Council Reference: DA09/0527  
Your Reference: MP05\_0198 MOD 4

17 August 2018

**Bilambil Heights Major Project Approval (MP05\_0198 MOD 4) - Walmsley Road and Stott Street BILAMBIL HEIGHTS**

LEVEL DATUM	SCALE 1: 1250
DATE OF SURVEY	REVISION R
DATE 18.03.16	SHEET 1 OF 3
DRAWN CBS	JOB No
CHECKED BG	35054
CAD FILE No. 35054-PROP

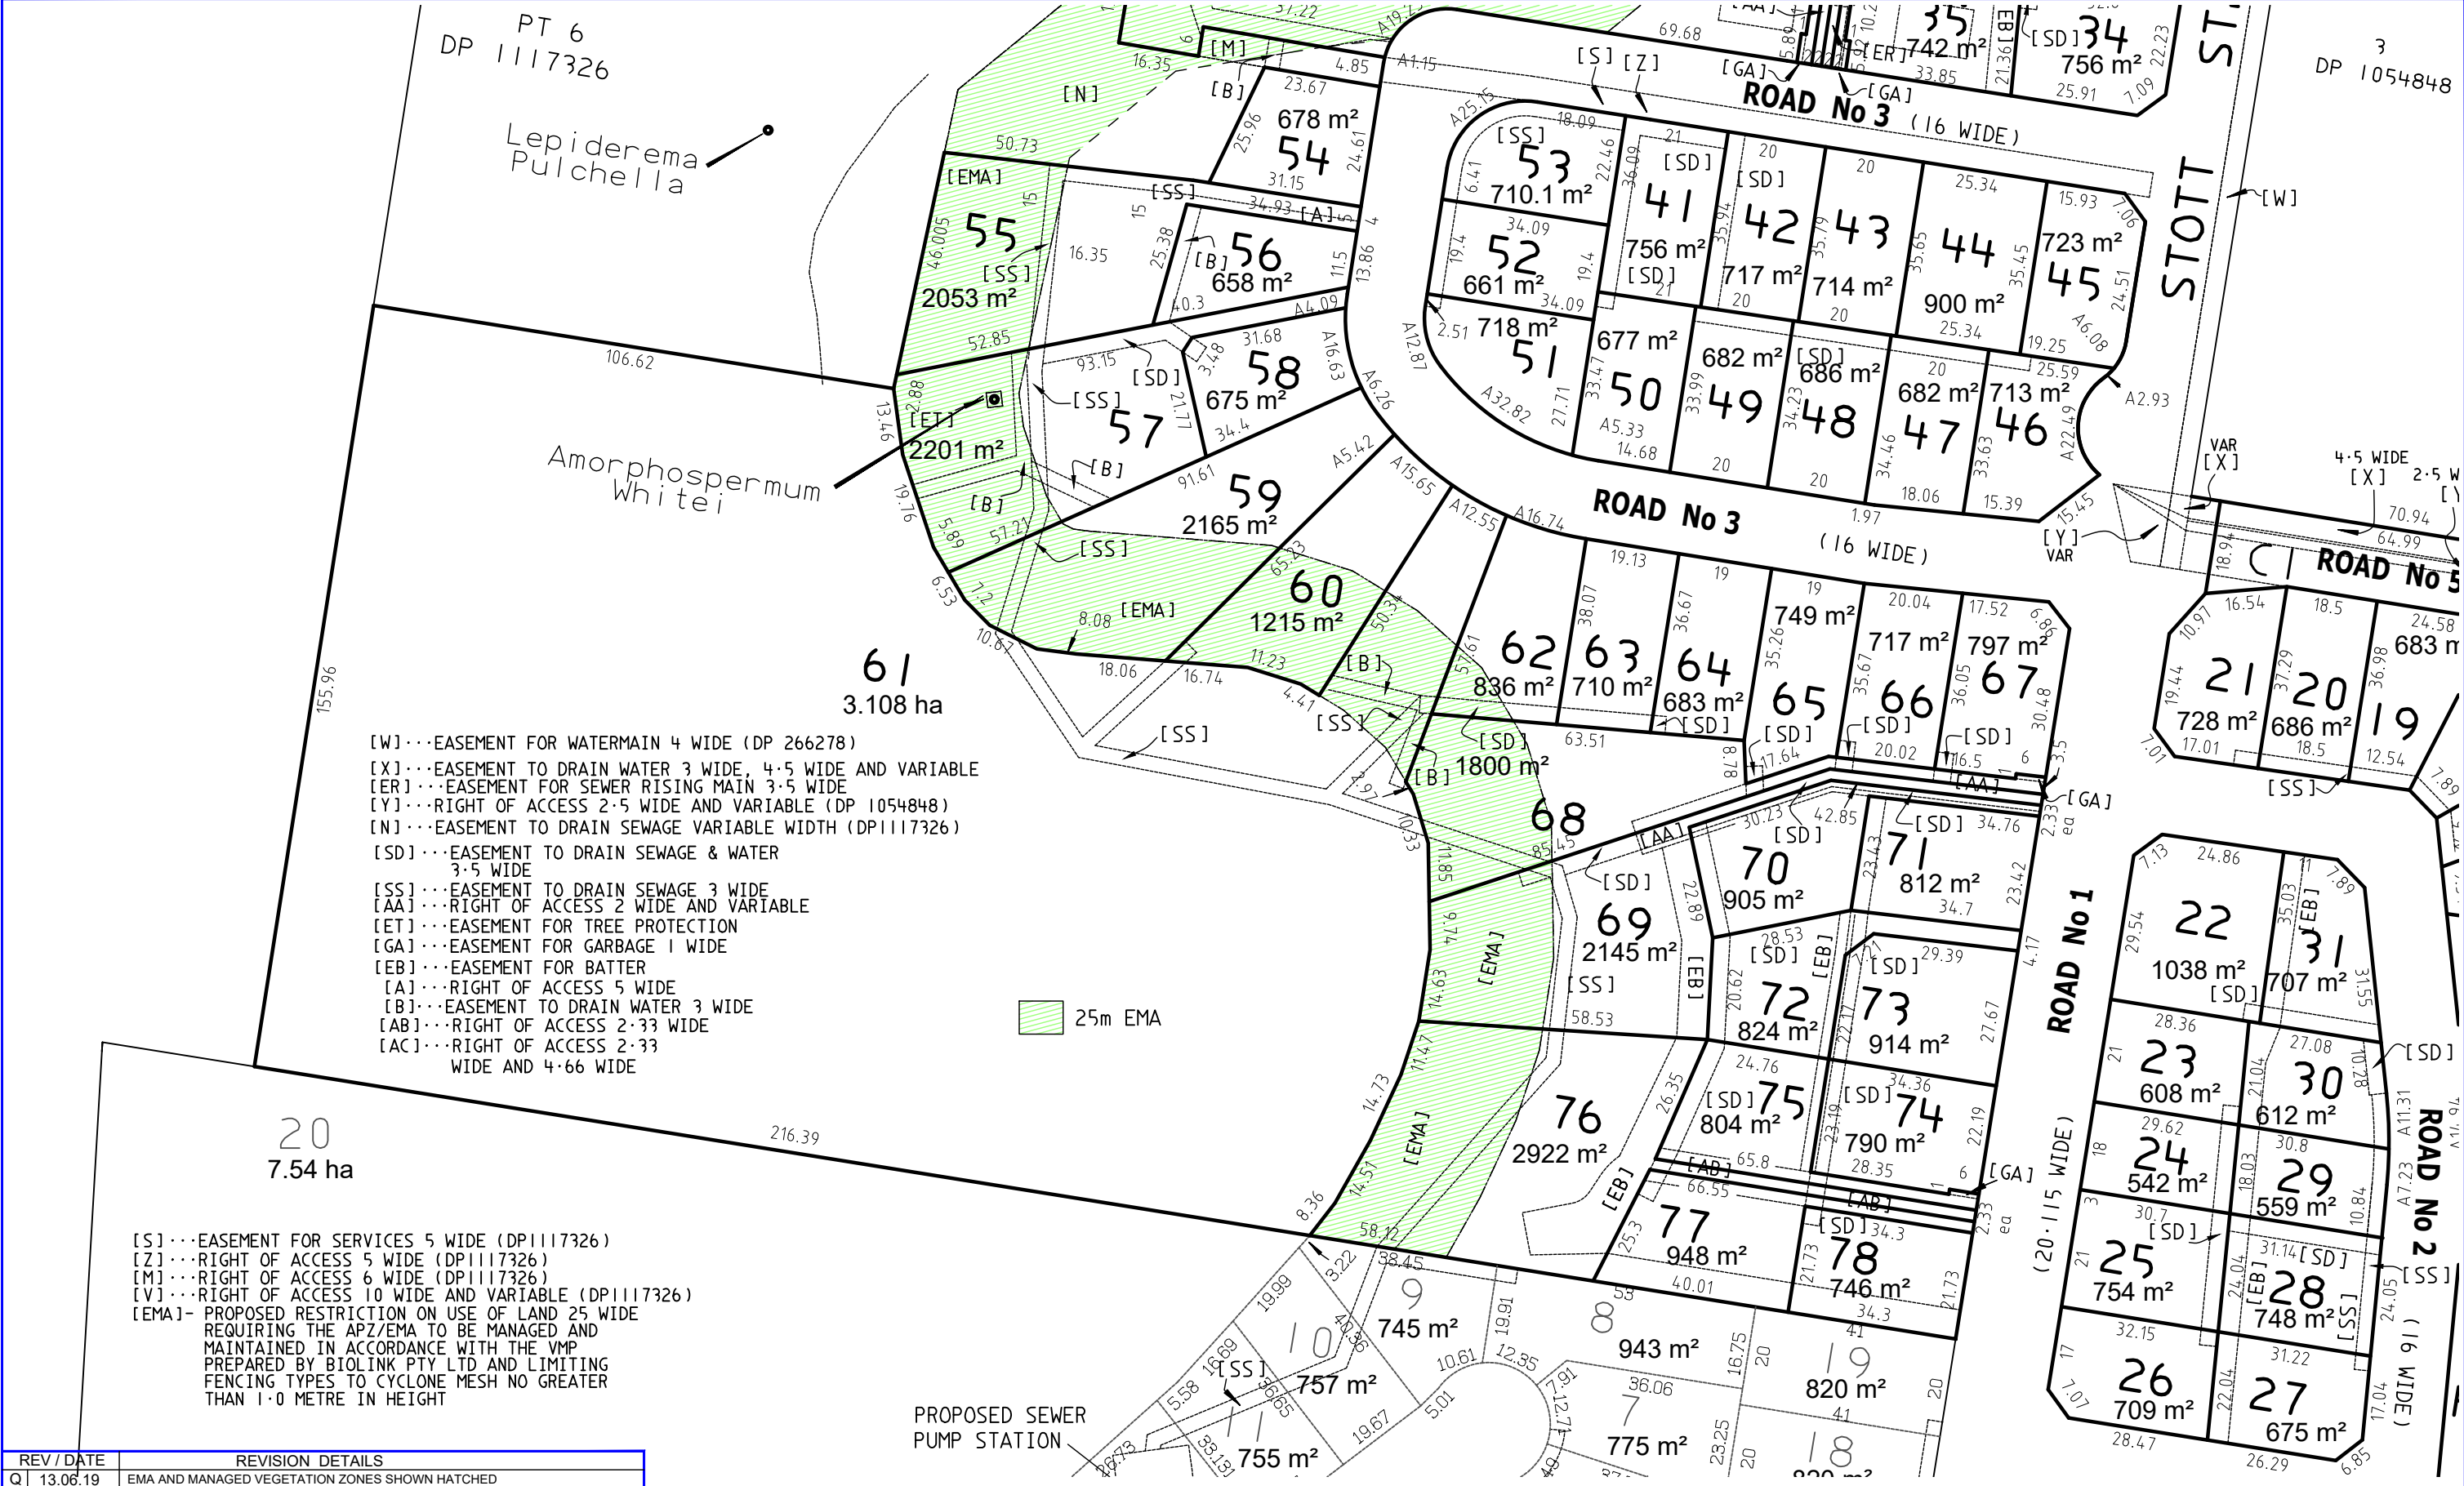
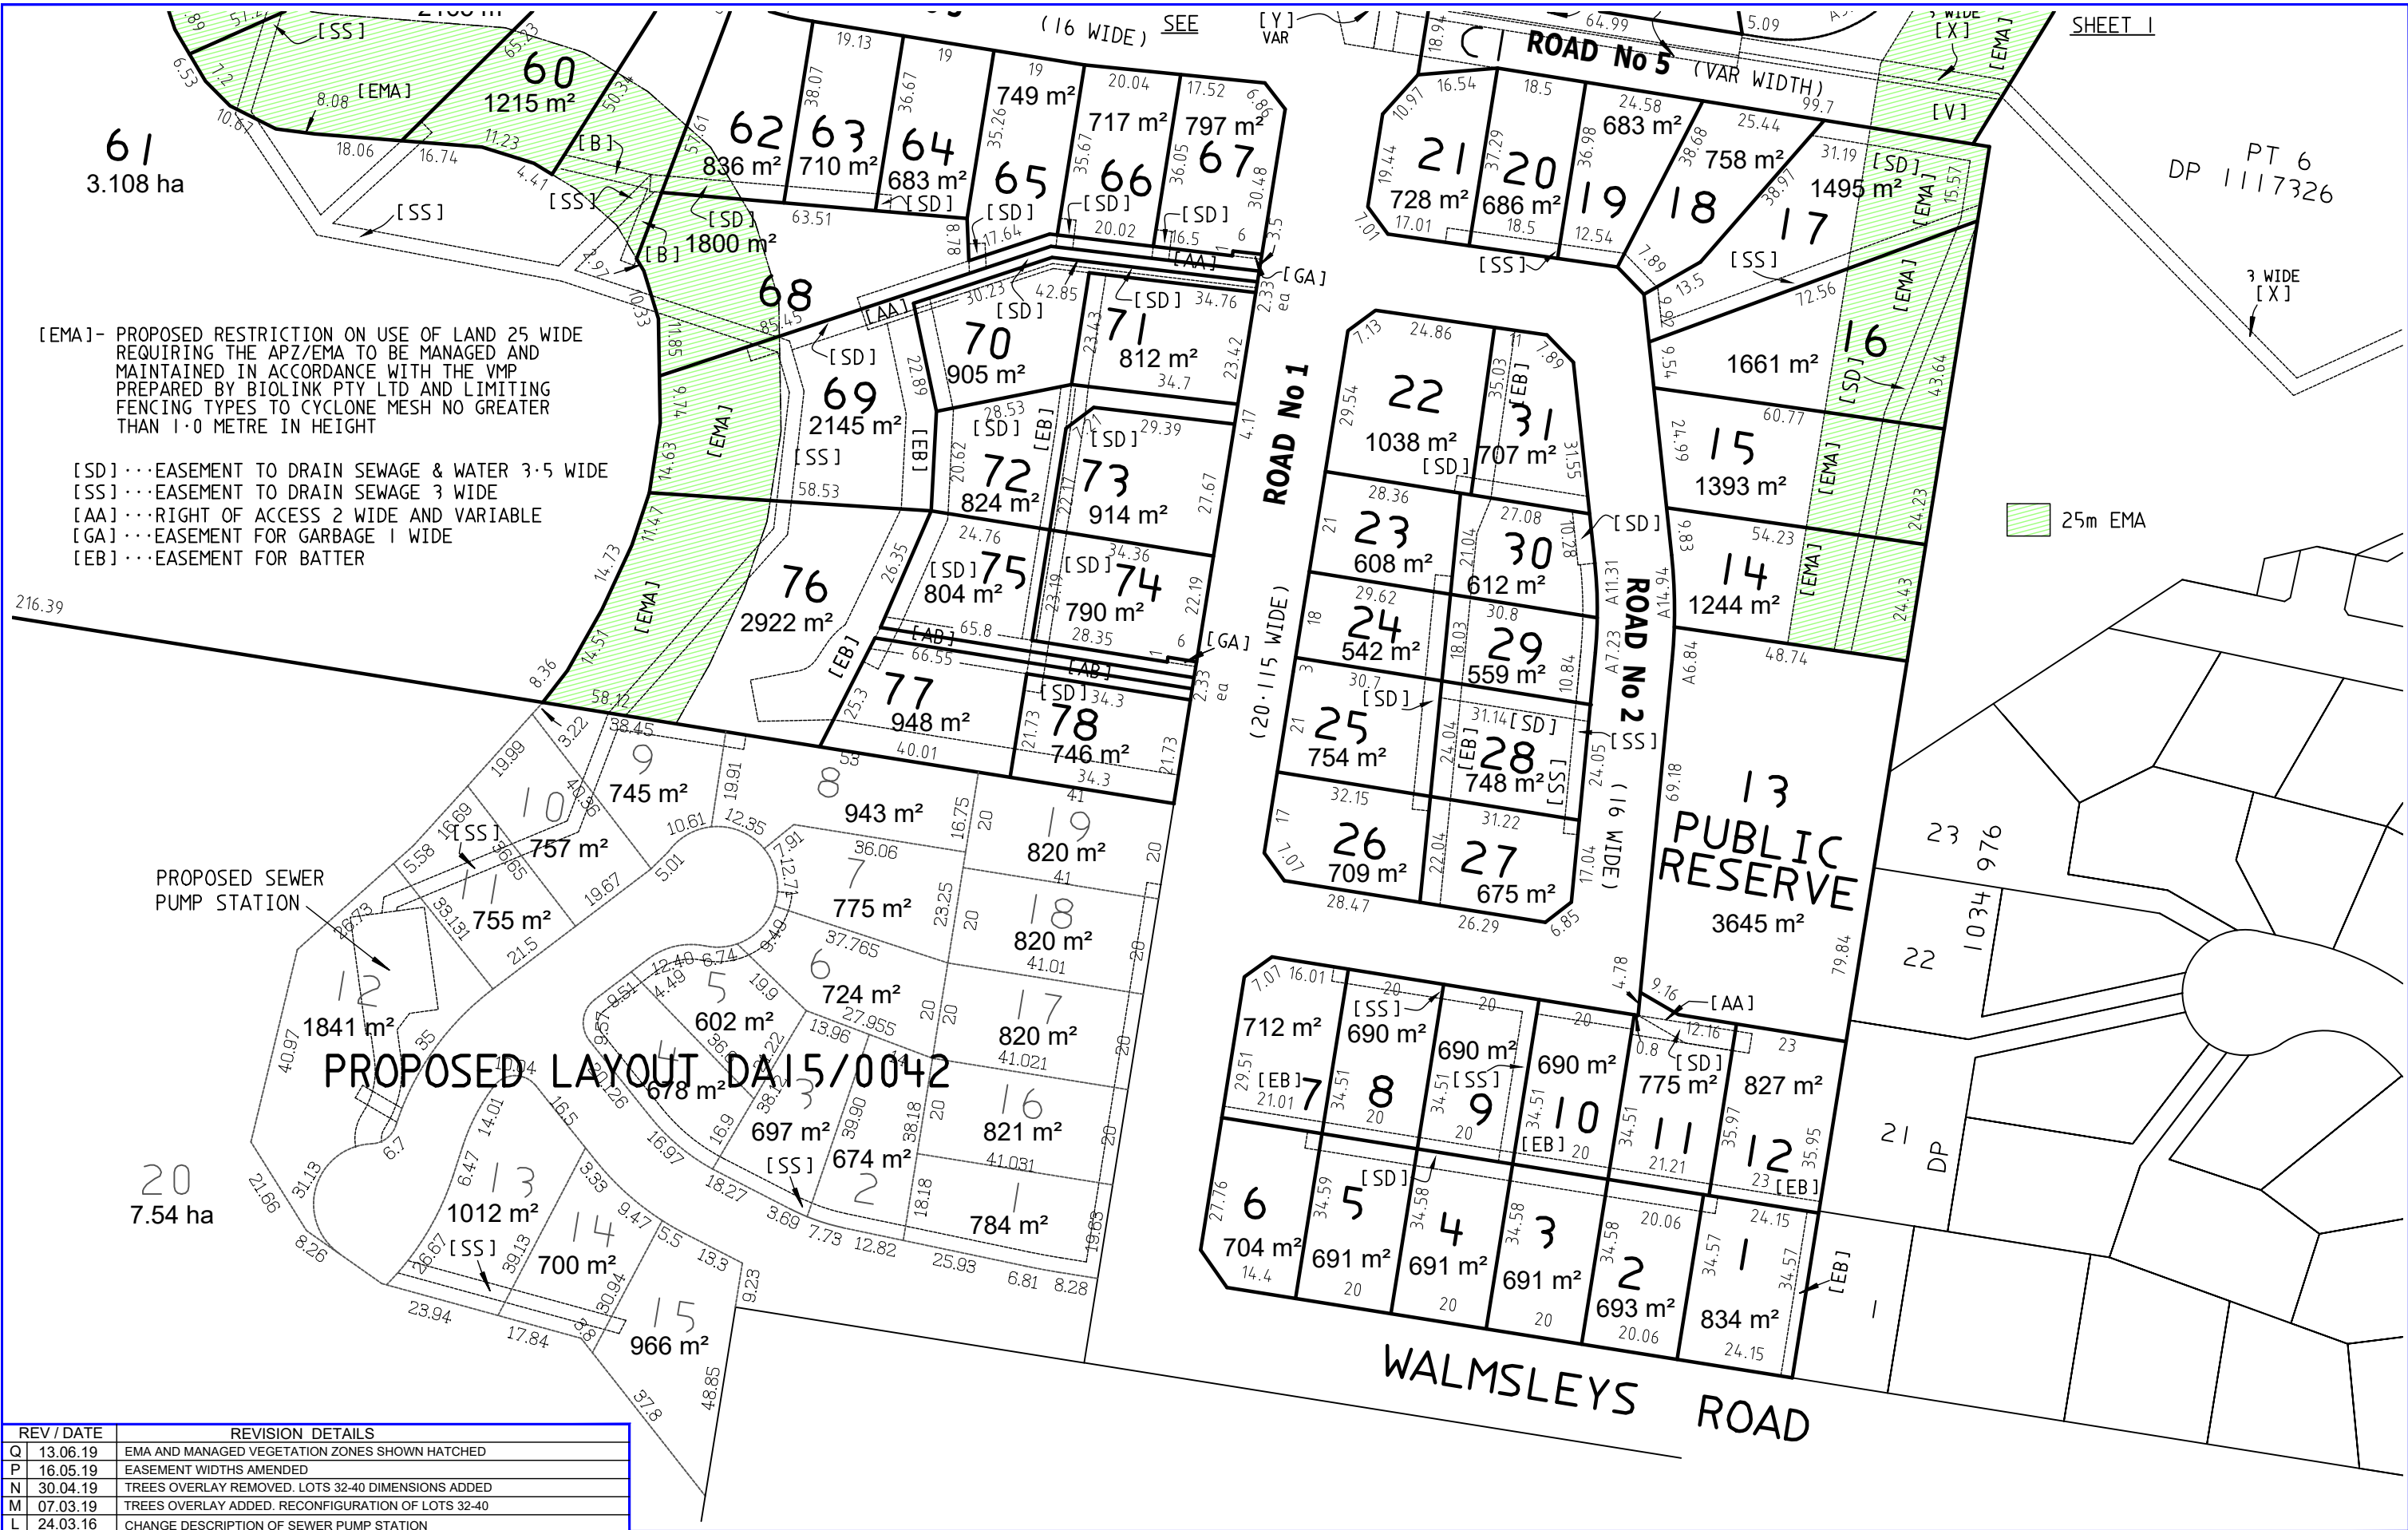
Based on the information submitted, it would appear that the proposed modification fails to address the broader scope of the issues at hand, and concerns are raised over the required APZ's and approved Environmental Management Areas (EMA's) resulting in future lots of land failing to contain a sufficient area to accommodate a dwelling. In this regard, the required EMA and APZ's on approved lots 38, 39 and 40 appear to be the most affected.

- Asset Protection Zones (APZ's) are proposed to extend beyond the EMA meets and bounds as shown on the approved subdivision plans. However, the restriction to the EMA is enforced in Condition B24 (1);
- Sections of the proposed APZ extend onto adjacent private land that did not form part of the subject application (to the east and west of the subject site);
- Proposed APZ's compromise expected habitat restoration works, noting that commitment to such works and sensitive treatment within the prescribed EMA was to be provided in lieu of allowing for adequate buffers between habitat and development Lots and;
- The plan lacks certainty for the long term protection of threatened flora species occurring within the proposed APZ, deferring assessment to a subsequent development stage following Lot creation.

- A Bushfire Threat Assessment Report (prepared by a BPAD Certified Practitioner) be submitted taking into account each of the approved lots and associated restrictions imposed in the development consent in terms of asset protection zone location, future use and commitment to vegetation management as prescribed in the relevant reports that supported the application and referenced in the conditions of consent.
- Based on the Bushfire Threat Assessment Report and subsequent Lot evaluation a determination should be made as to whether modification to the lot layout may be necessary to achieve a development pattern that does not result in any additional impact on ecological values than that contemplated during previous subdivision assessment nor compromise commitments to habitat restoration as approved.
